## EL PASO COUNTY STORMWATER MANAGEMENT PLAN CHECKLIST

Revised: October 2021

**SITE GRADING, DRAINAGE, LANDSCAPING, AND EROSION CONTROL PLAN**  
**WATER TREATMENT PLANT BUILDING ADDITION**  
 SECURITY WATER DISTRICT

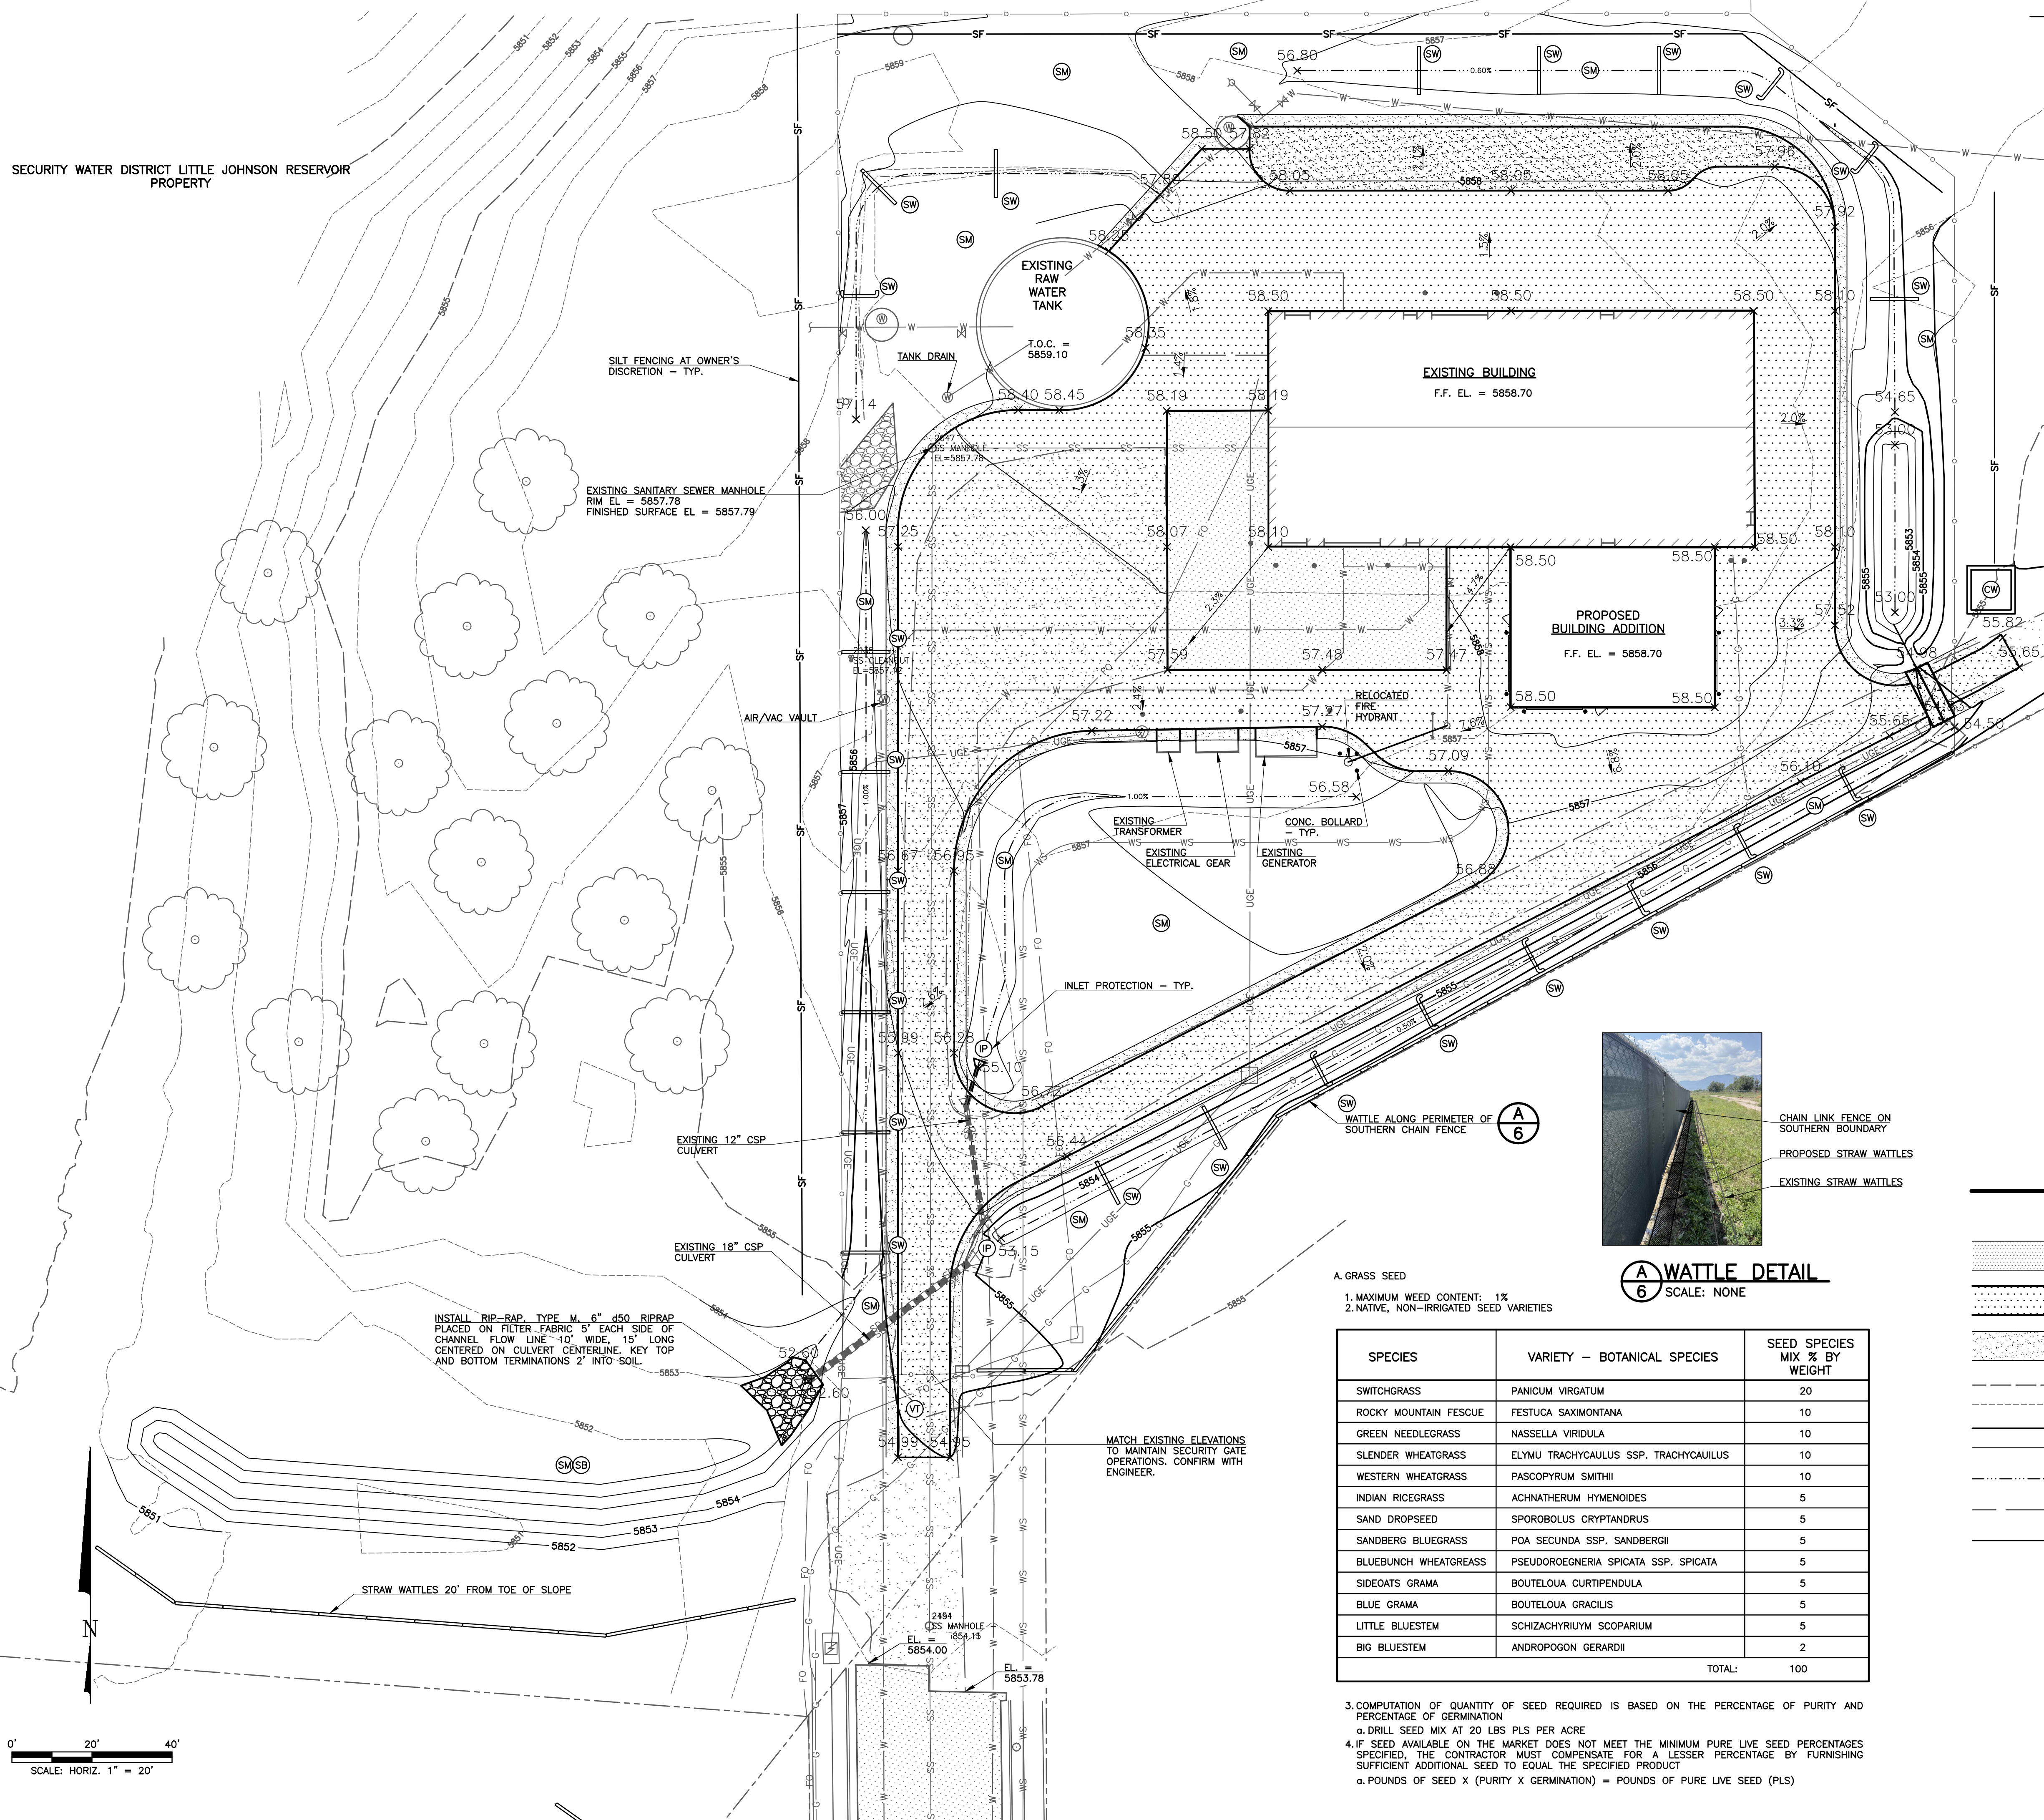
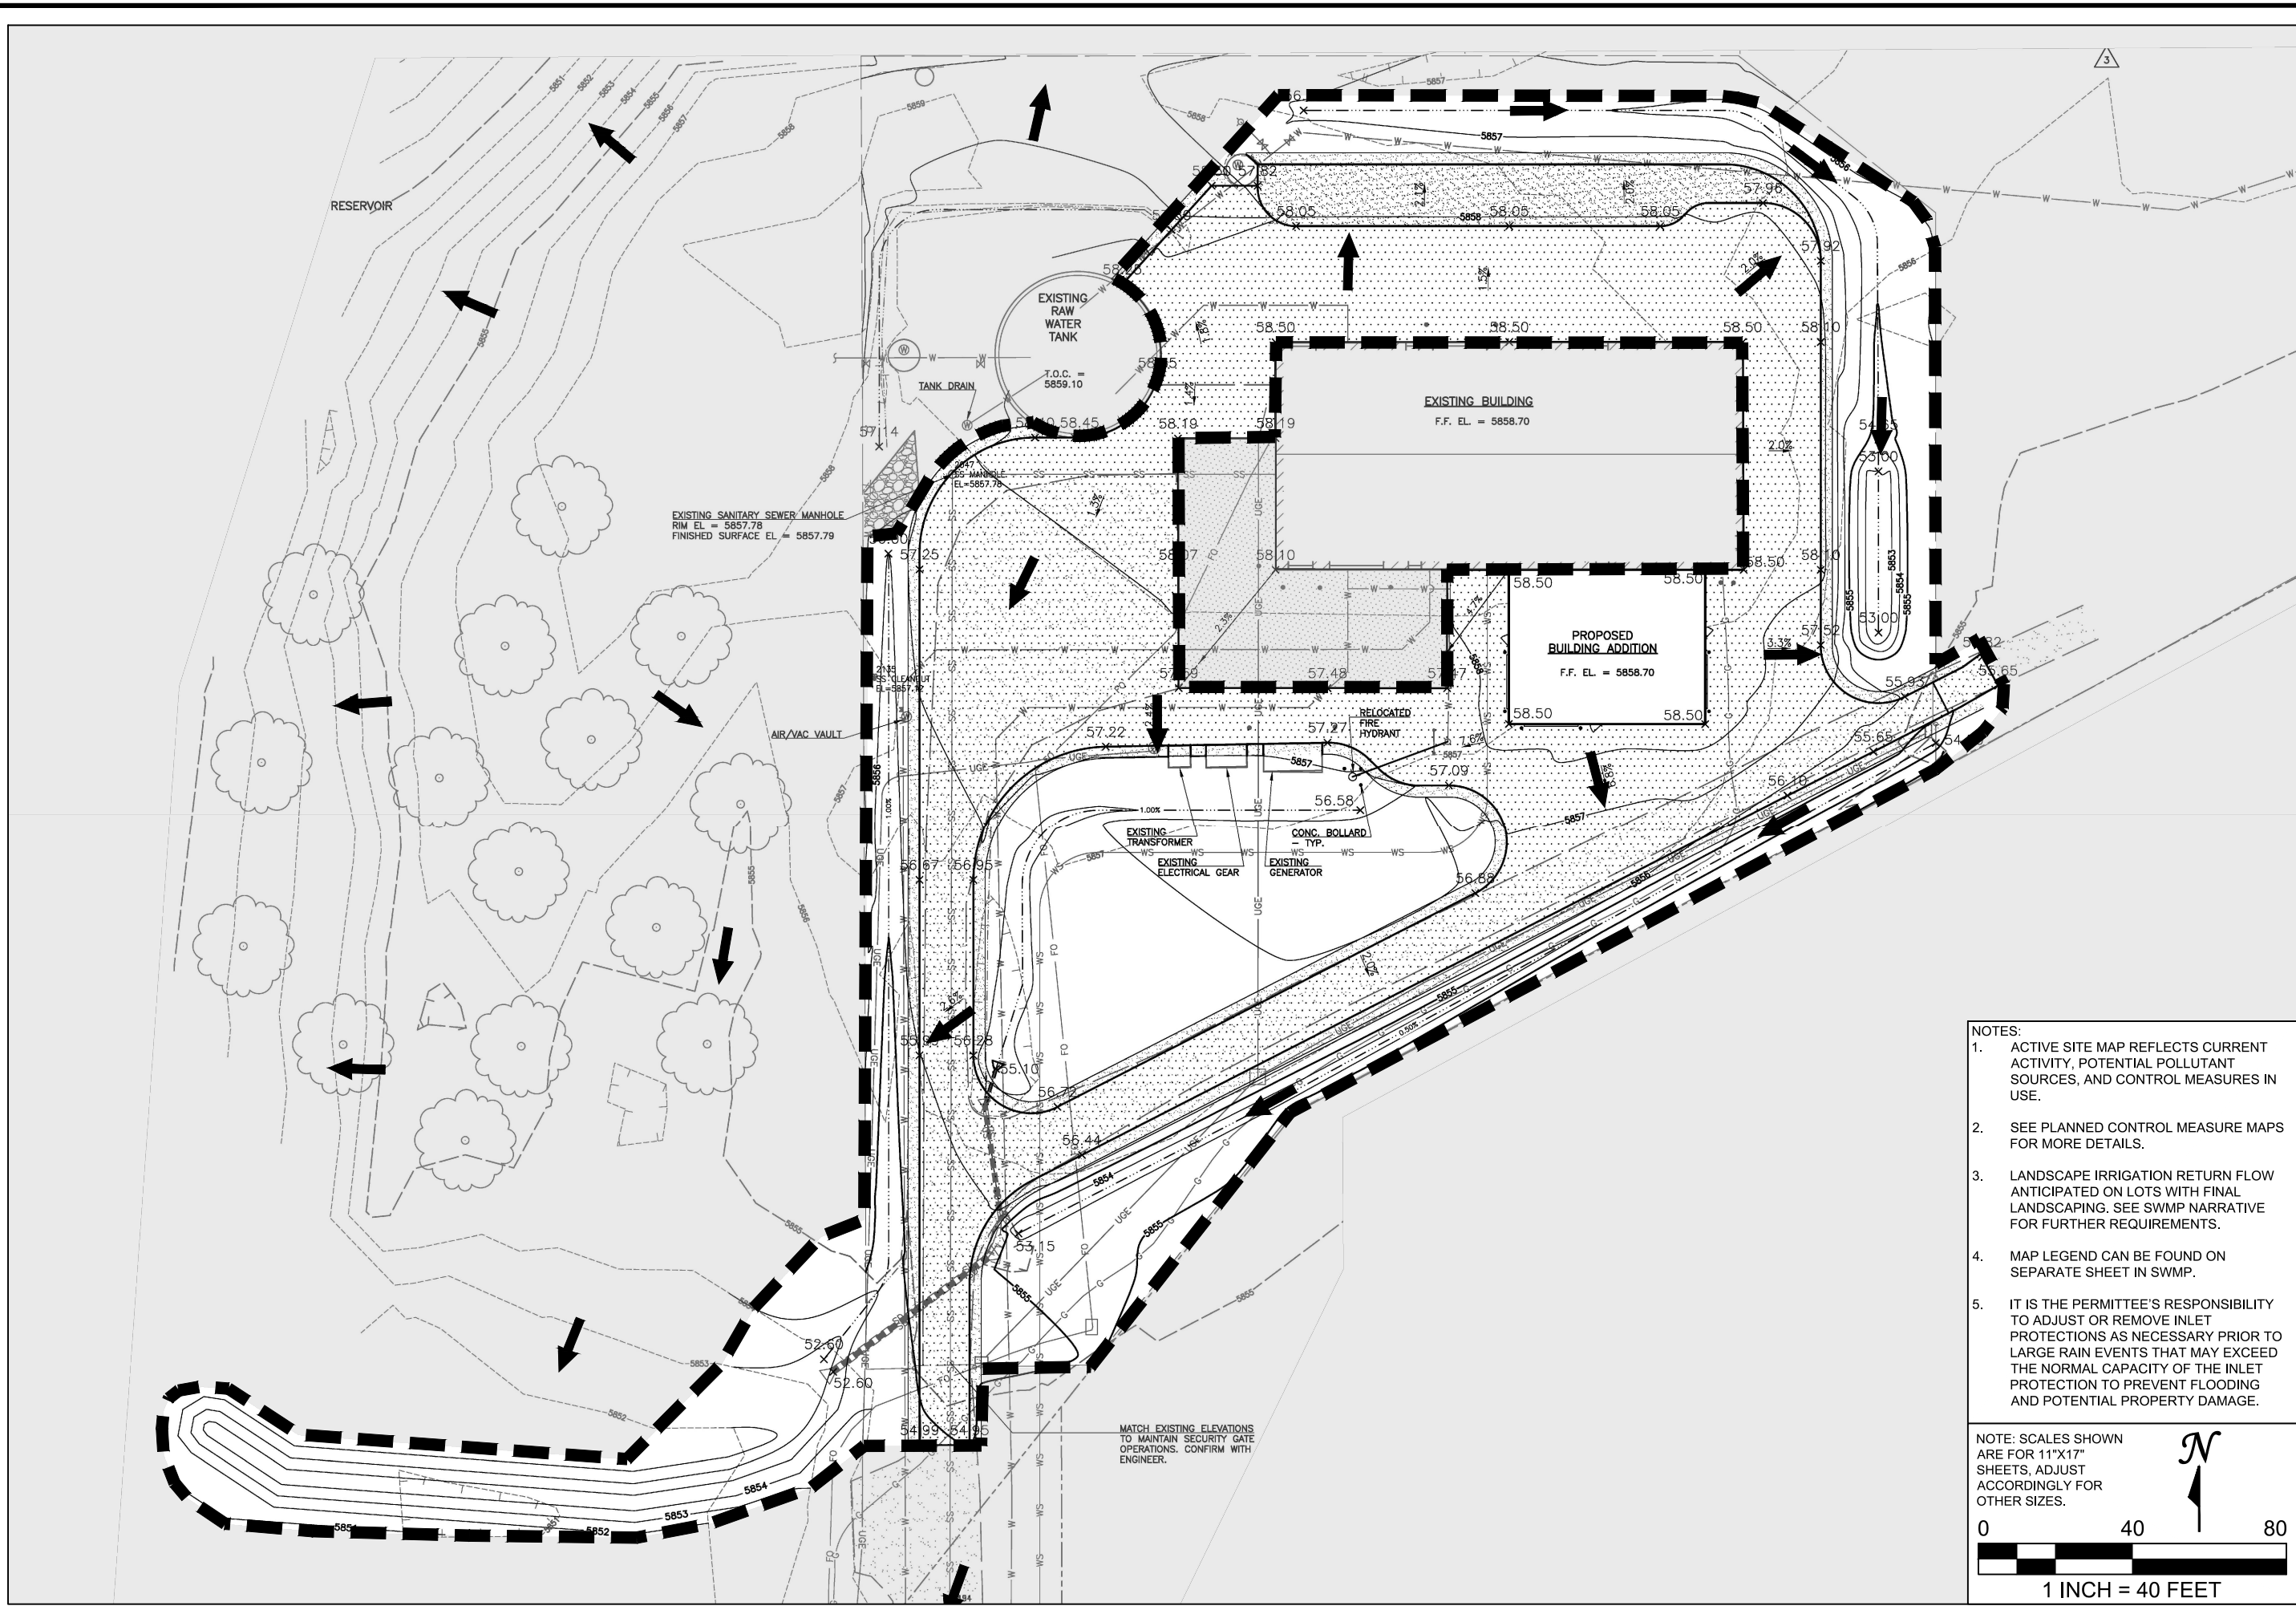
7	Estimates of the total site area and area to undergo disturbance; current area of disturbance must be updated on the SWMP as changes occur <span style="color: red; font-size: small;">Refer to Para.5.3. Area revised to be 3.0 acres with addition of waste soil and paving materials holding sitse and access road to site.</span>		
8	Soil erosion potential and impacts on discharge that includes a summary of the data used to determine soil erosion potential		
9	A description of existing vegetation at the site and percent ground cover and method used to determine ground cover		
10	Location and description of all potential pollution sources including but not limited to: disturbed and stored soils; vehicle tracking; management of contaminated soils; loading and unloading operations; outdoor storage of materials; vehicle and equipment maintenance and fueling; significant dust generating process; routine maintenance activities involving fertilizers, pesticides, herbicides, detergents, fuels, solvents, oils, etc.; on-site waste management; concrete truck/equipment washing; dedicated asphalt, concrete batch plants and masonry mixing stations; non-industrial waste such as trash and portable toilets
